**EL PASO COUNTY PLANNING AND
 COMMUNITY DEVELOPMENT
 DEPARTMENT**

GRADING AND EROSION CONTROL PLAN CHECKLIST

Revised: July 2019

C10

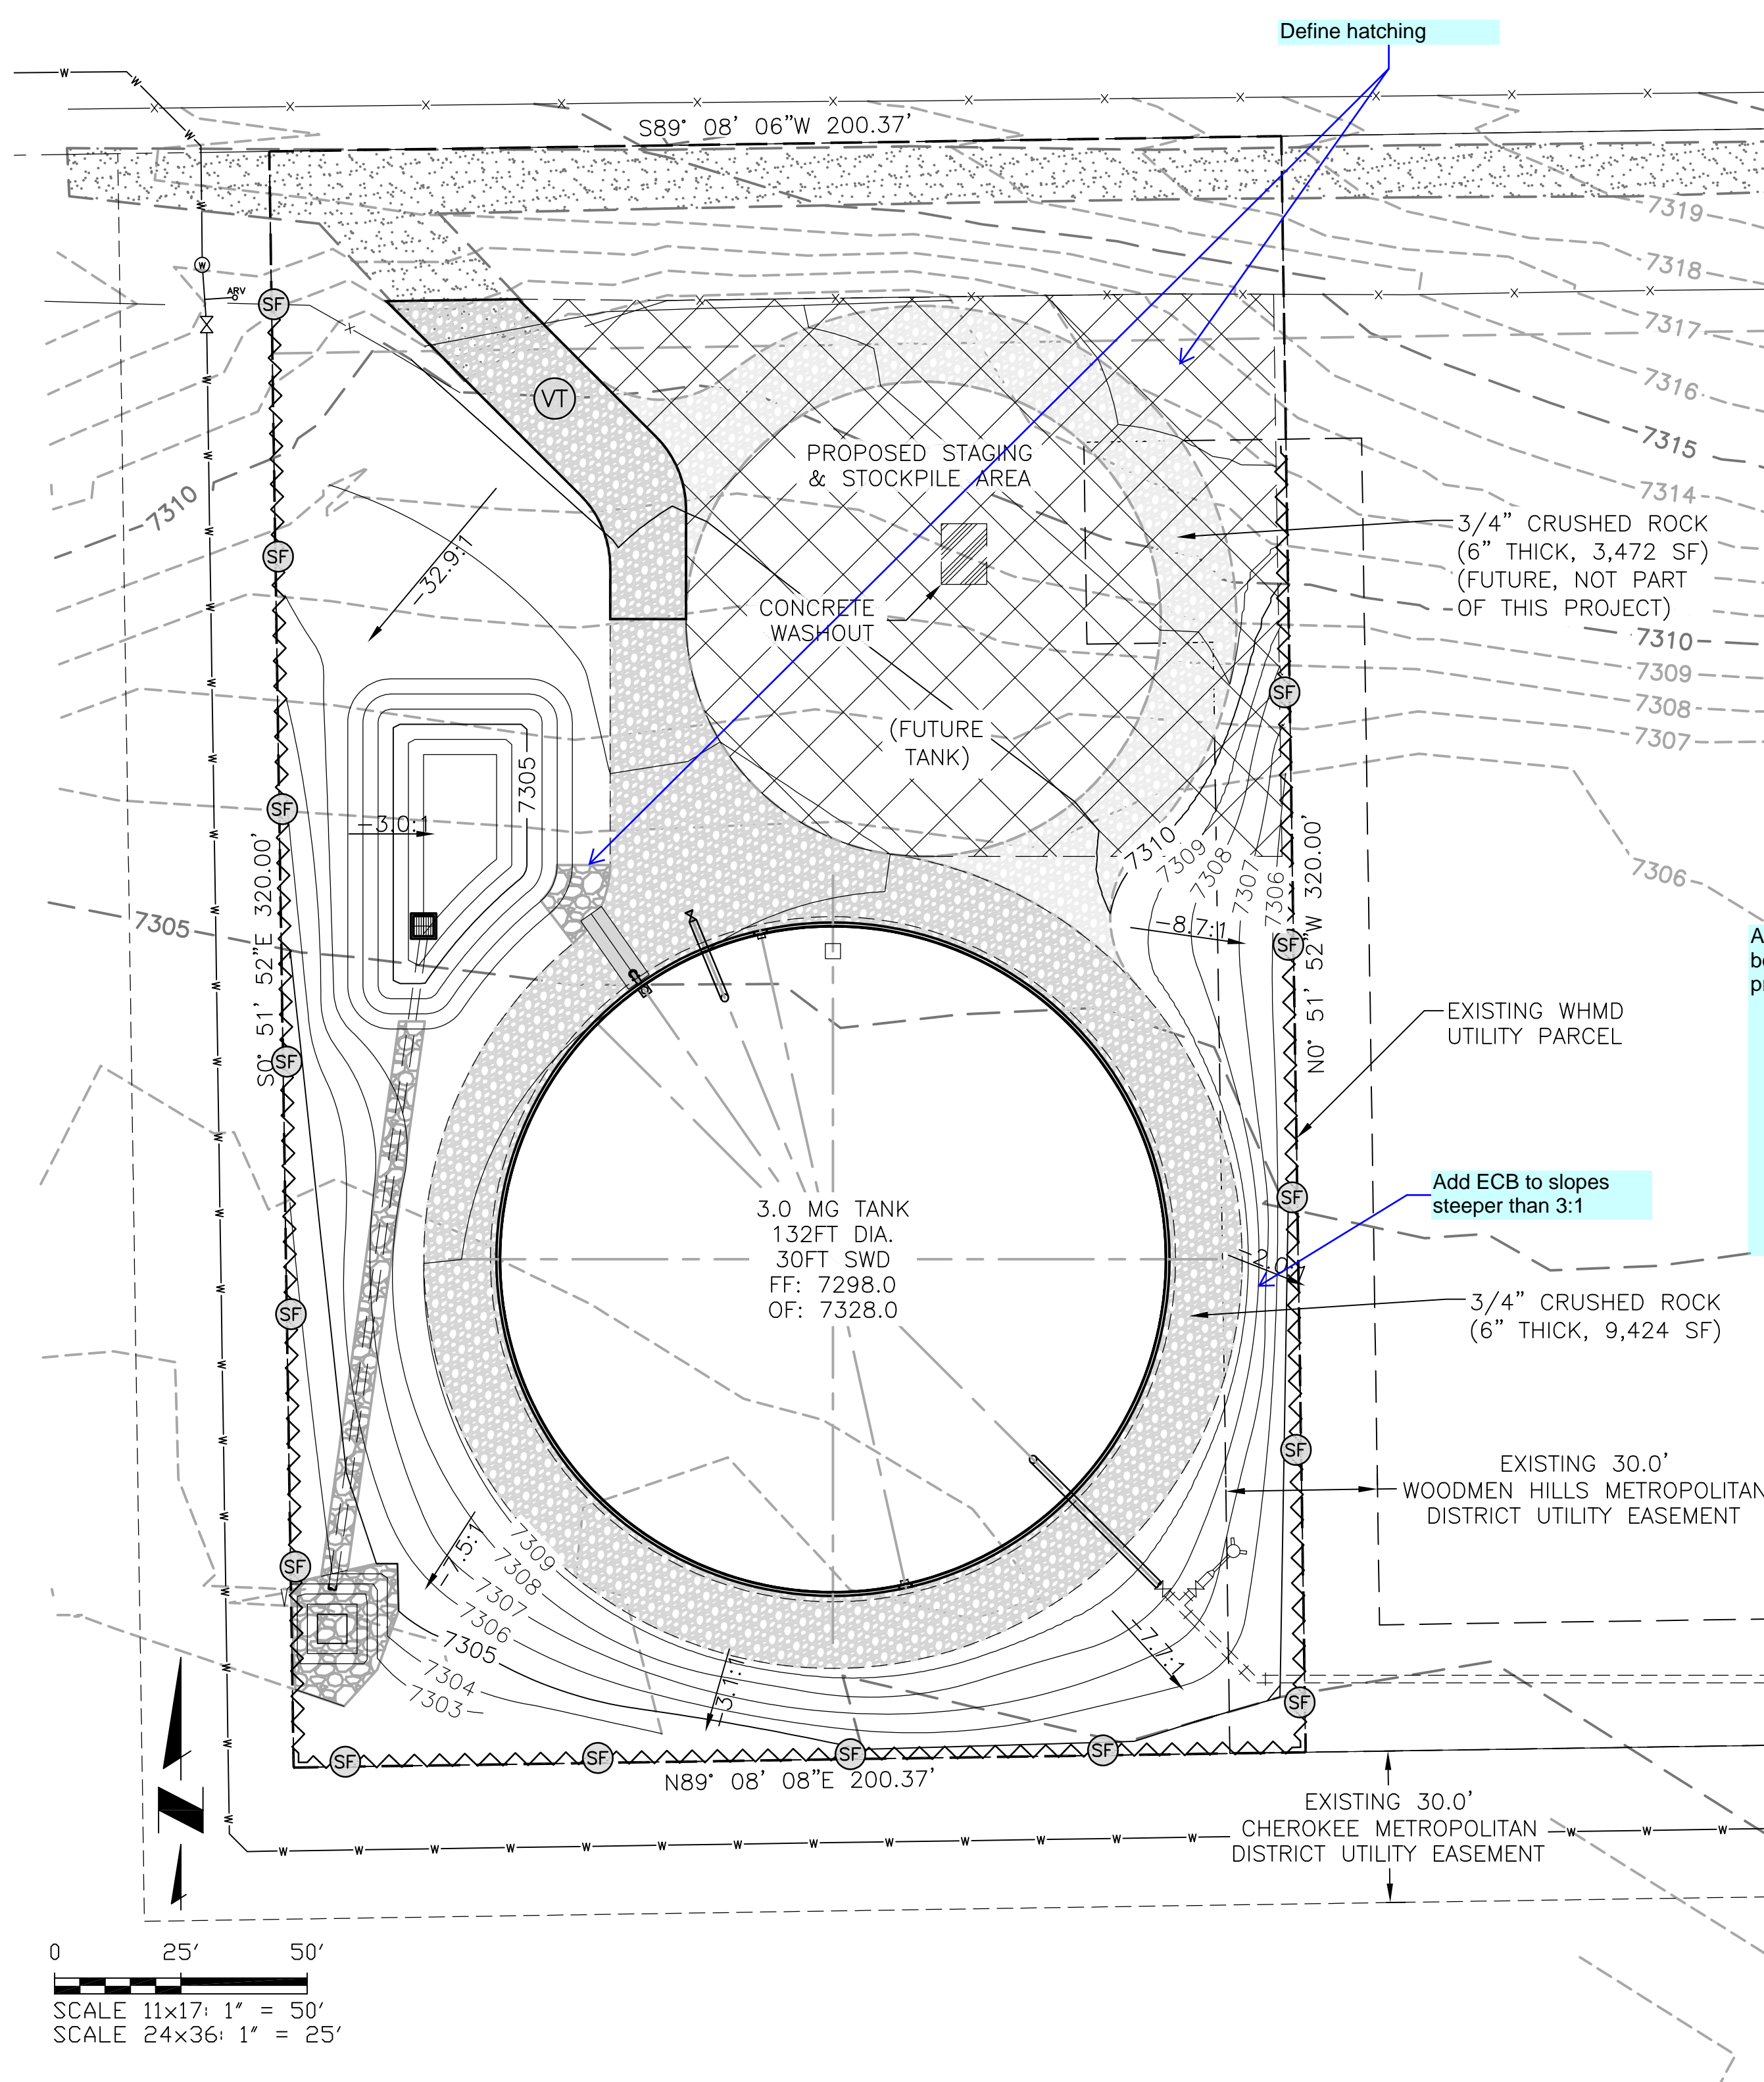
Applicant	PCD
1. GRADING AND EROSION CONTROL PLAN			
a	Vicinity map.	X	✓
b	Adjacent city/town/jurisdictional boundaries, subdivision names, and property parcel numbers labeled.	X	✓
c	North arrow and acceptable scale (1"=20' to 1"=100').	X	✓
d	Legend for all symbols used in the plan.	X	X
e	Existing and proposed property lines. Proposed subdivision boundary for subdivision projects.	X	✓
f	All existing structures.	X	✓
g	All existing utilities.	X	✓
h	Construction site boundaries.	X	✓
i	Existing vegetation (notes are acceptable in cases where there is no notable vegetation, only grasses/weeds, or site has already been stripped).	X	✓
j	FEMA 100-yr floodplain.	X	N/A
k	Existing and proposed water courses including springs, streams, wetlands, detention ponds, stormwater quality structures, roadside ditches, irrigation ditches and other water surfaces. Show maintenance of pre-existing vegetation within 50 feet of a receiving water.	X	✓

v	All proposed temporary construction control measures, structural and non-structural. Temporary construction control measures shall be identified by phase of implementation to include "initial," "interim," and "final" or shown on separate phased maps identifying each phase.	X	X
w	Vehicle tracking provided at all construction entrances/exits. Construction fencing, barricades, and/or signage provided at access points not to be used for construction.	X	✓
x	Temporary sediment ponds provided for disturbed drainage areas greater than 1 acre.	N/A	N/A
y	Dewatering operations to include locations of diversion, pump and discharge(s) as anticipated at time of design.	N/A	N/A
z	All proposed temporary construction control measure details. Custom or other jurisdiction's details used must meet or exceed EPC standards.	X	✓

4. Applicant Comments:			
a	x. Due to the amount of structural fill required for the project the entire site is surrounded in silt fence that will be inspected and cleaned in accordance with the SWMP. These will serve as sediment control. t. There are no asphalt/concrete batch plants proposed for the project. y. Groundwater is not expected to be encountered based on the recent geotechnical evaluation, and therefore dewatering operations are not required.		
b	aa. There are no offsite stormwater control measure proposed for use by the project. dd. There are no retaining walls proposed for use on the project. gg. and ii. Standalone GEC Plan submitted for the project.		
c	c. The project is not located within the floodplain. d. The project is not located within the floodplain/wetlands. e. This project does not propose a revision to the FEMA map. f. A State Engineer's permit is not required for this project. j. There is no pre-development site grading proposed for this project. k. There are no conditions of approval currently established for this project.
